CITY OF ALBUQUERQUE

**Re: Champion Xpress Car Wash
Erosion and Sediment Control Plan
Engineer's Stamp Date 2-15-19 (F20E005)**

C-1.1

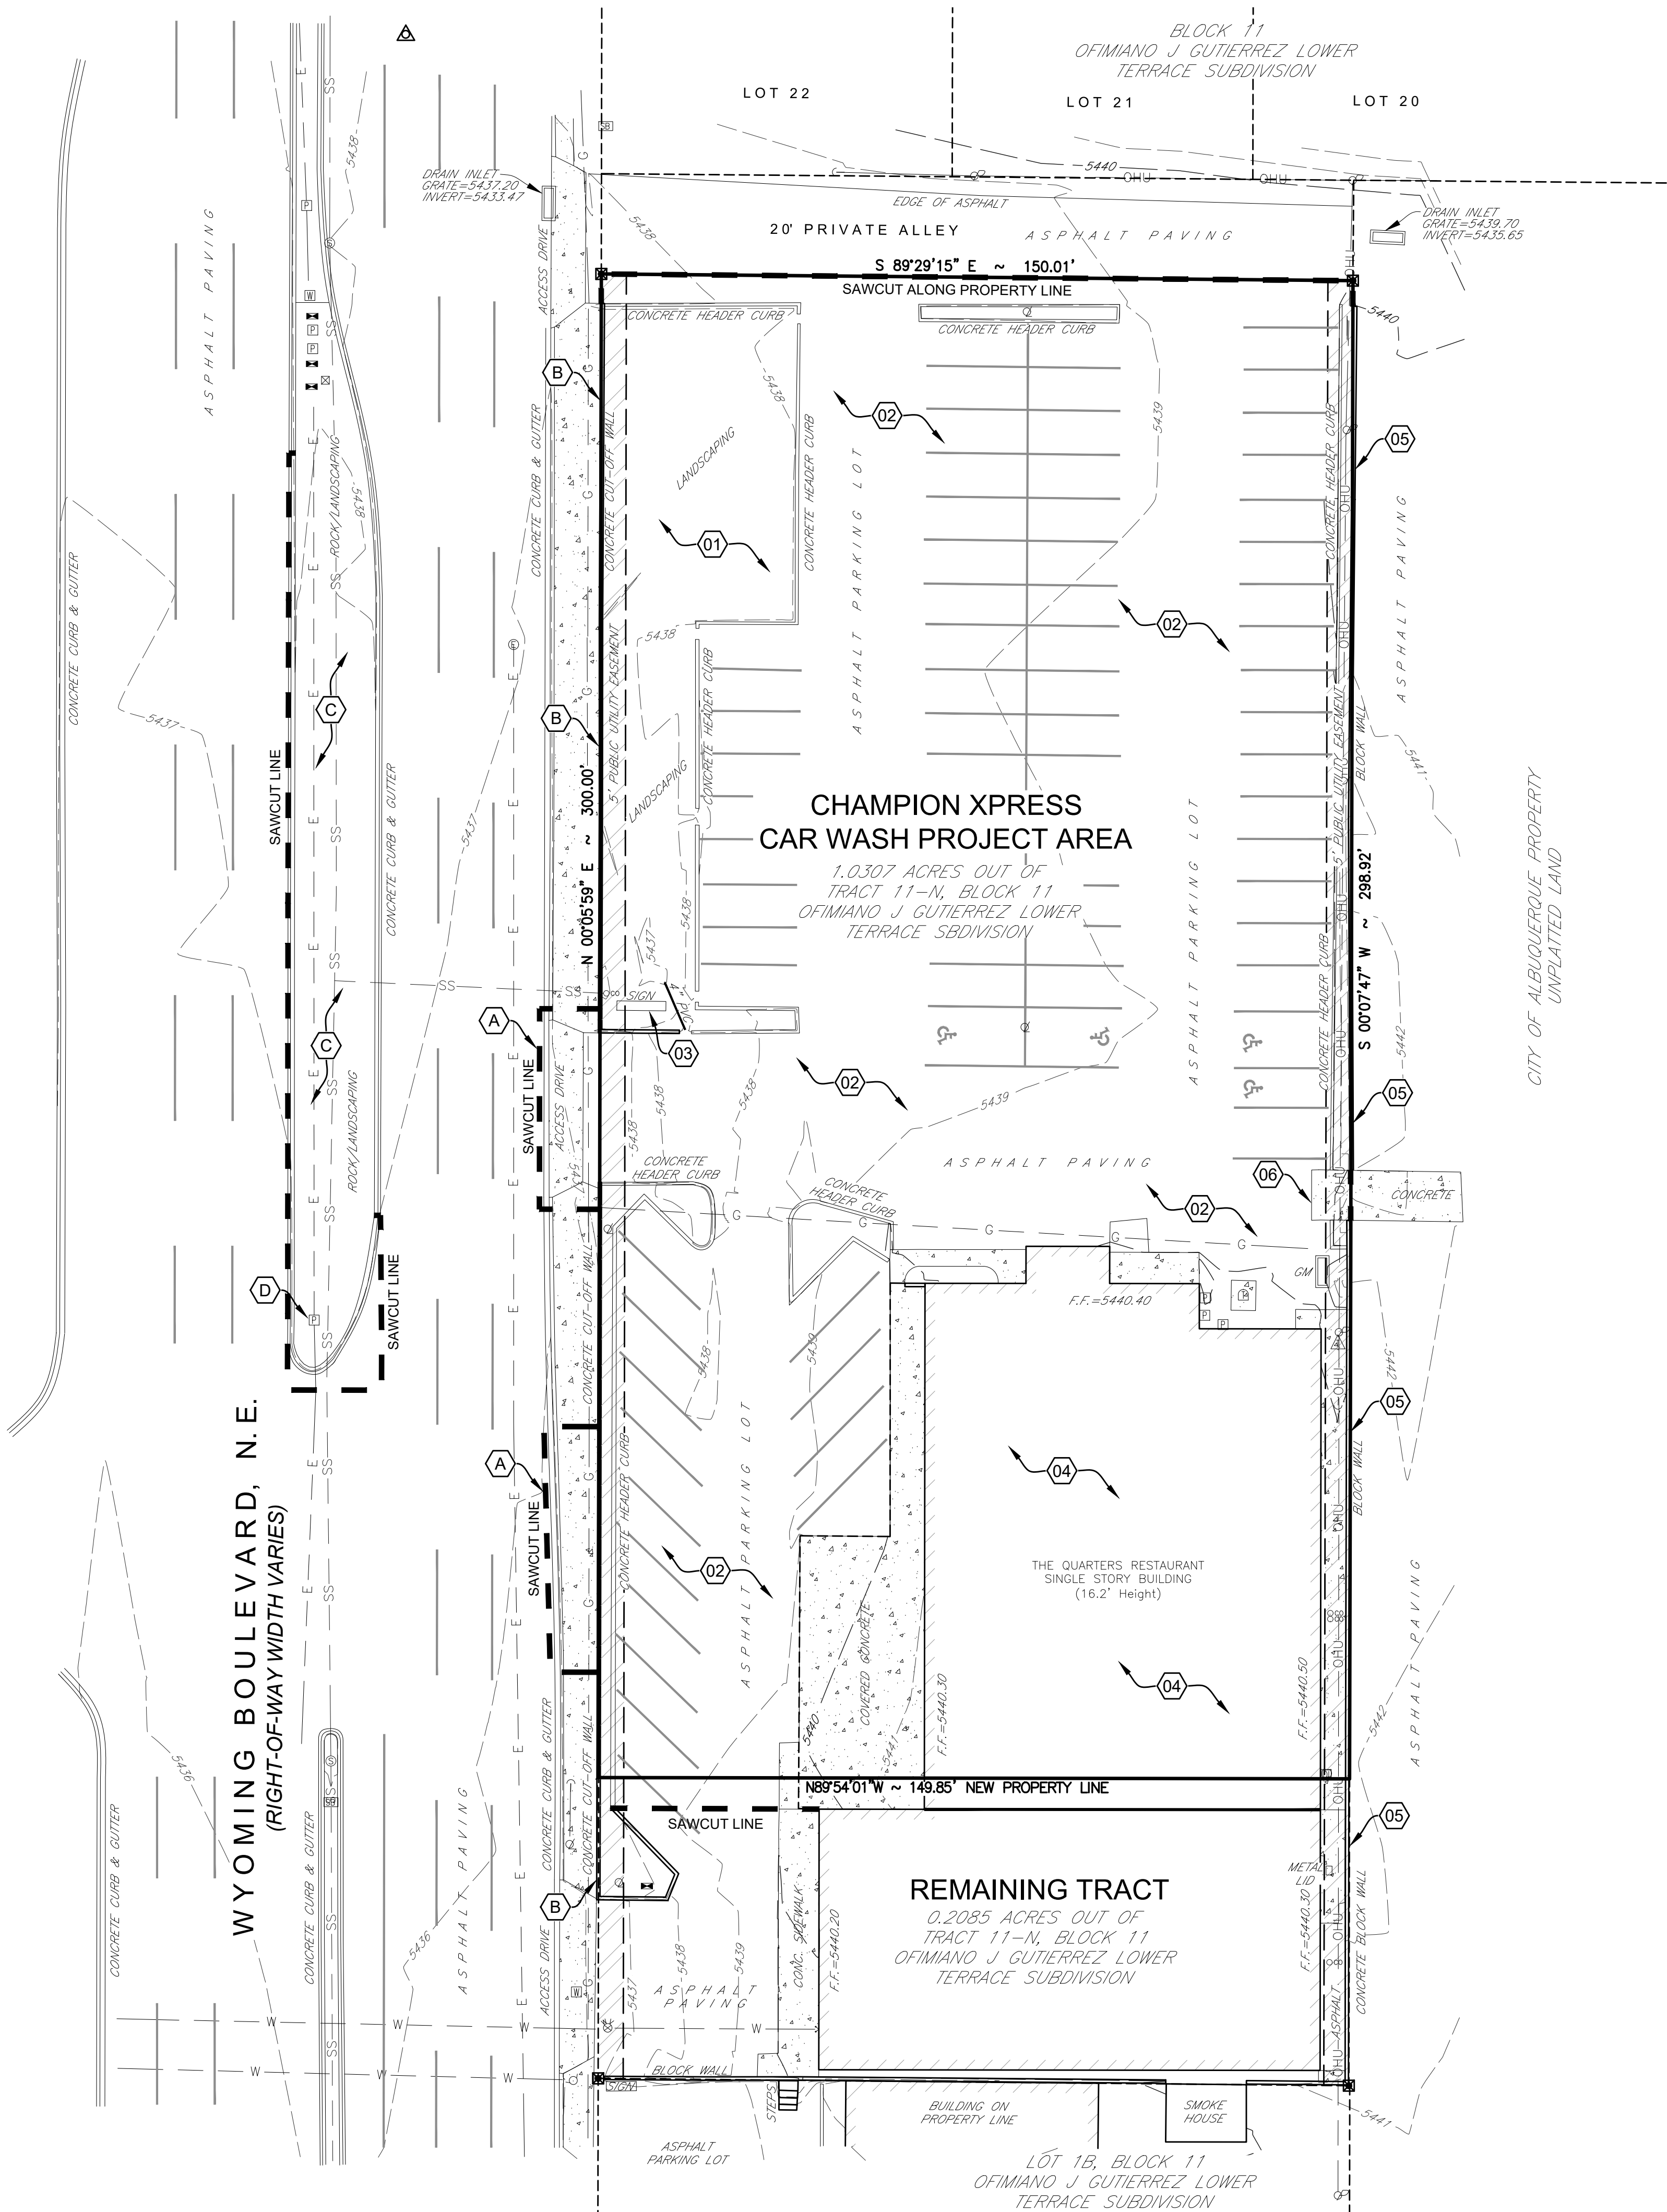
1. BMPs may be required for the construction in Wyoming Blvd. This will be discussed with the contractor(s)/owner when the construction in Wyoming Blvd begins.
